Application for a non-material amendment following a grant of planning permission.

PROPOSED DEMOLITION OF EXISTING BUNGALOW AND ERECTION OF A TWO-STORY DWELLING WITH GARAGE AND GRANNY ANNEXE. ALTERATIONS TO EXISTING ACCESS AND ASSOCIATED EXTERNAL WORKS.

3/2023/0660

6179 -01-03D Rev

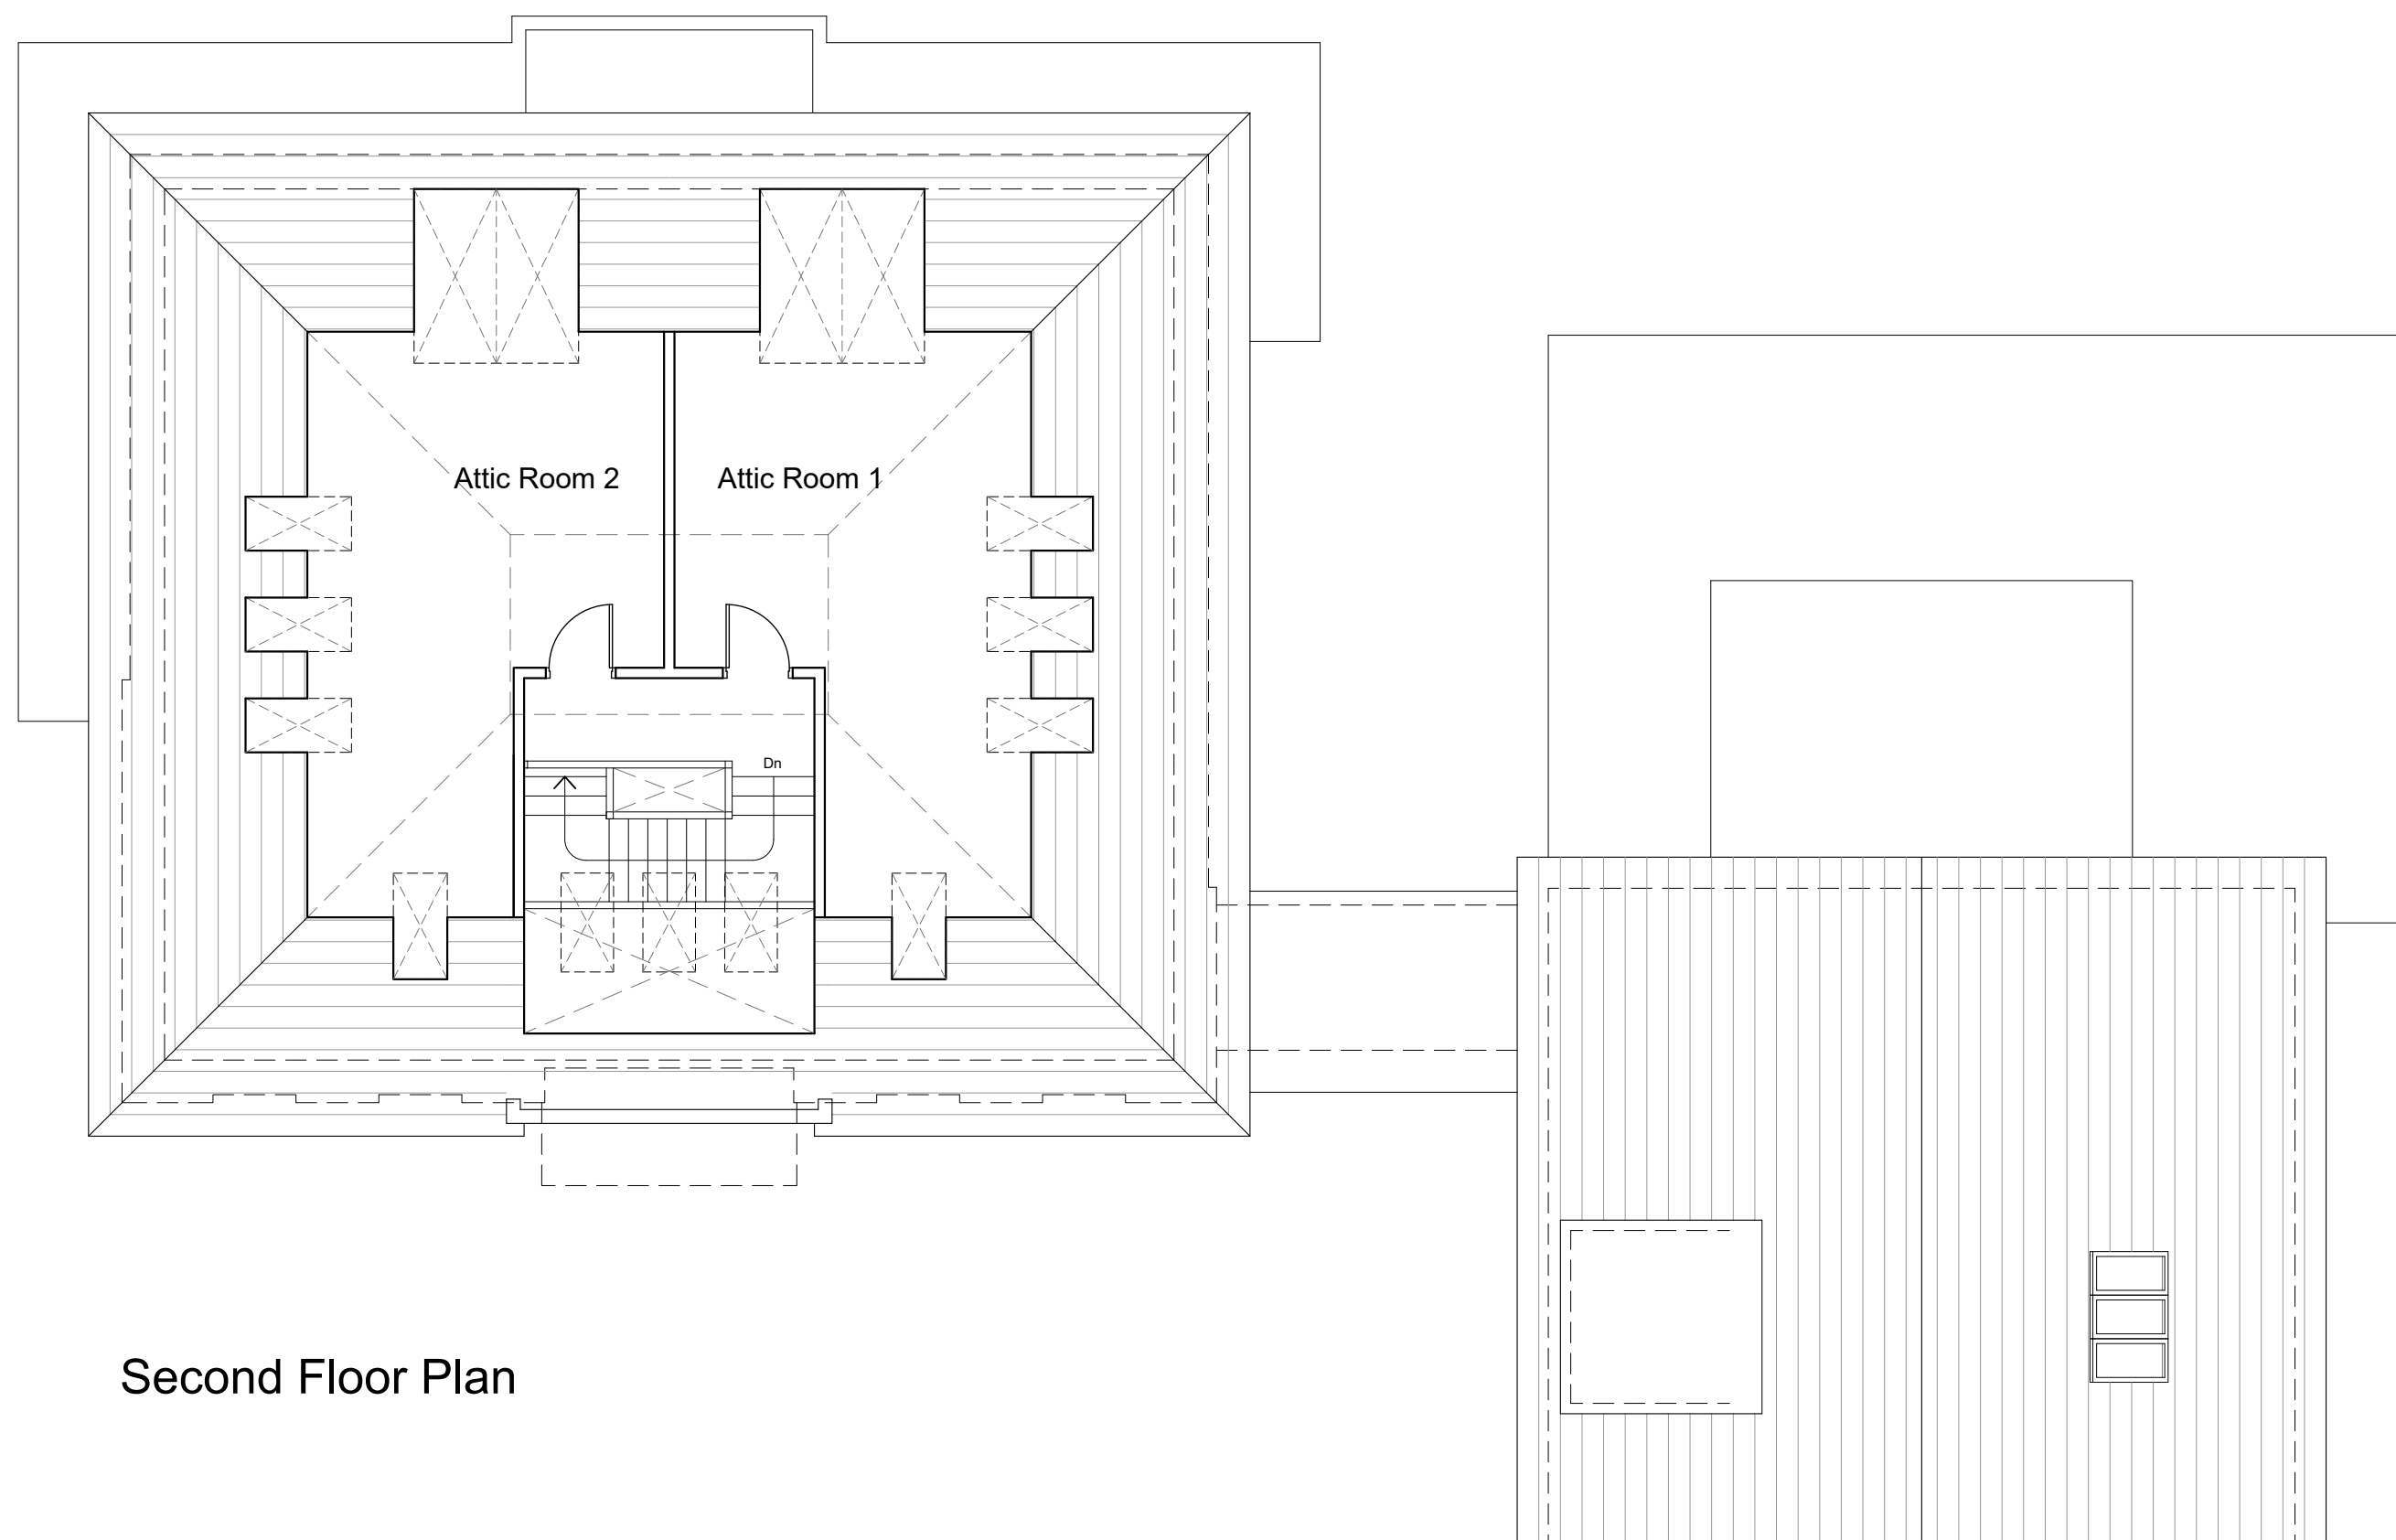
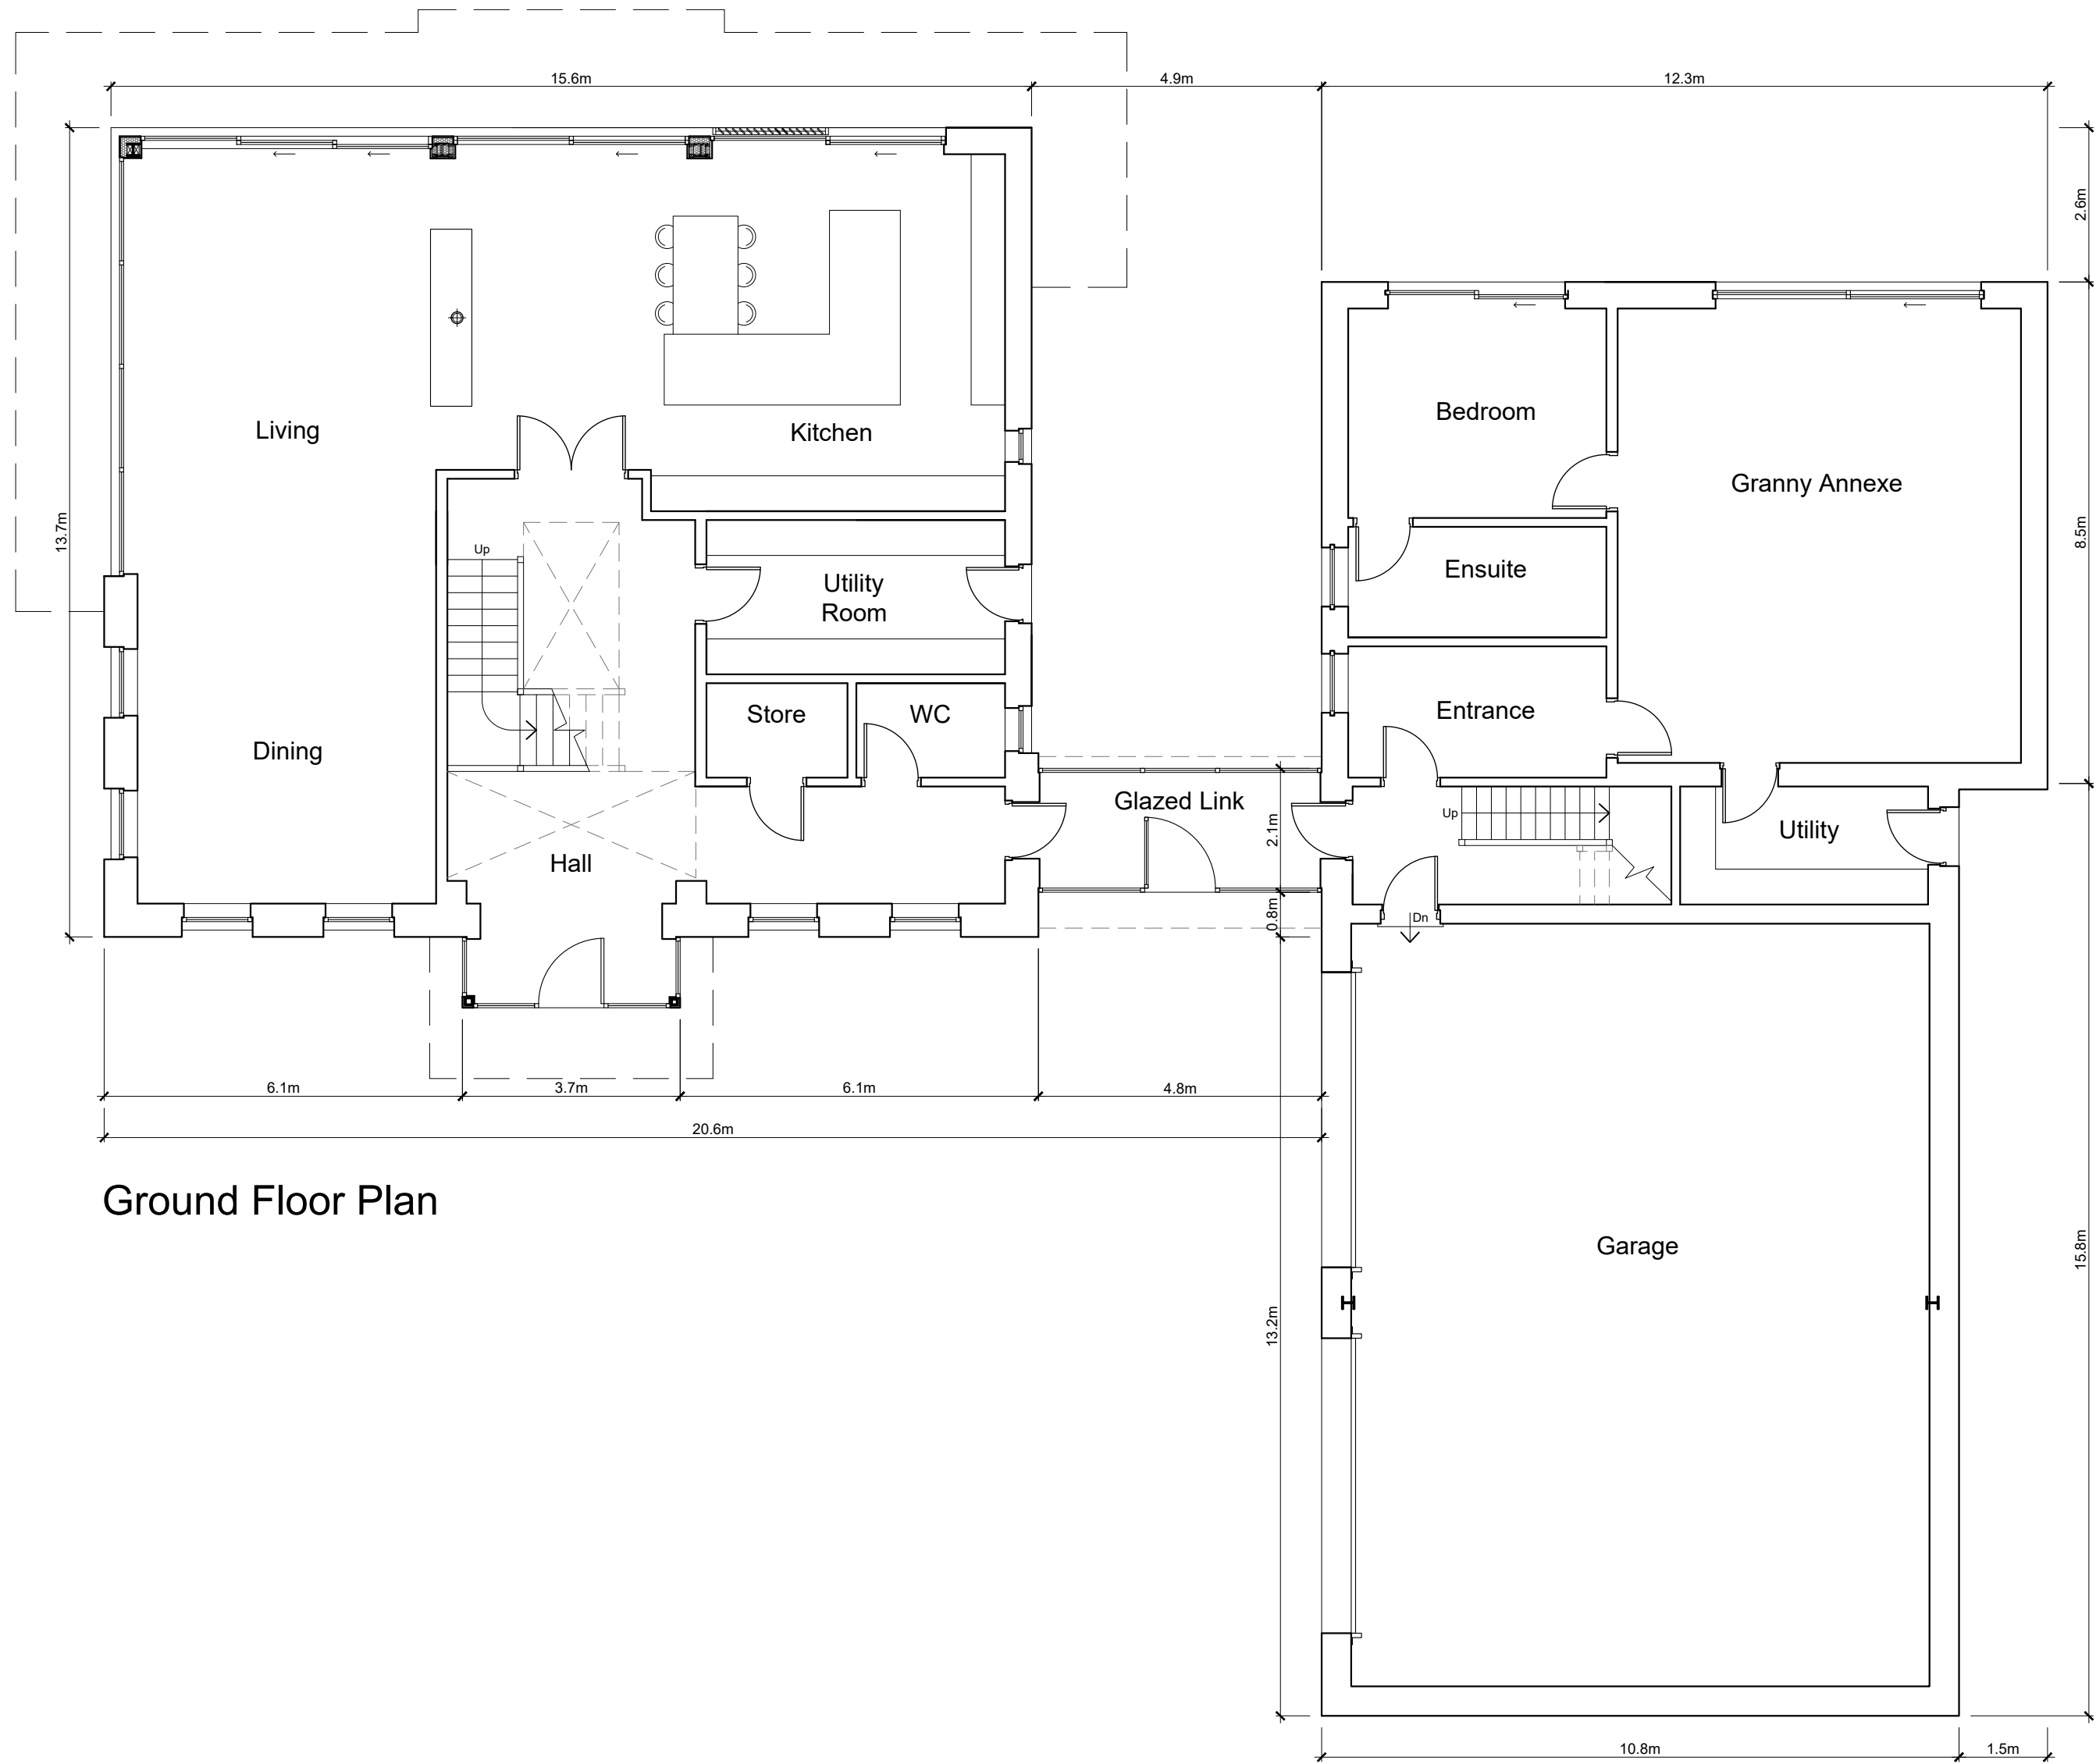
- ① OMISSION OF TWO GARAGE WINDOWS ON THE NORTH WEST ELEVATION
- ② DESIGN MODIFICATION TO TWO APPROVED DOORWAY WINDOWS ON THE GARAGE
- ③ OMISSION OF THE INSET ROOF BALCONY ON THE SOUTH EAST SIDE OF THE HOUSE AND ADDITION OF TWO SETS OF VELUX CASERO - ROOF WINDOWS
- ④ OMISSION OF THE GLAZED CORNER WALL ON THE SOUTH EAST & SOUTH WEST ELEVATIONS SERVING THE GRANNY ANNEXE, LEAVING GLAZED OPENINGS JUST ON THE SOUTH EAST ELEVATION SERVING THE GRANNY ANNEXE.
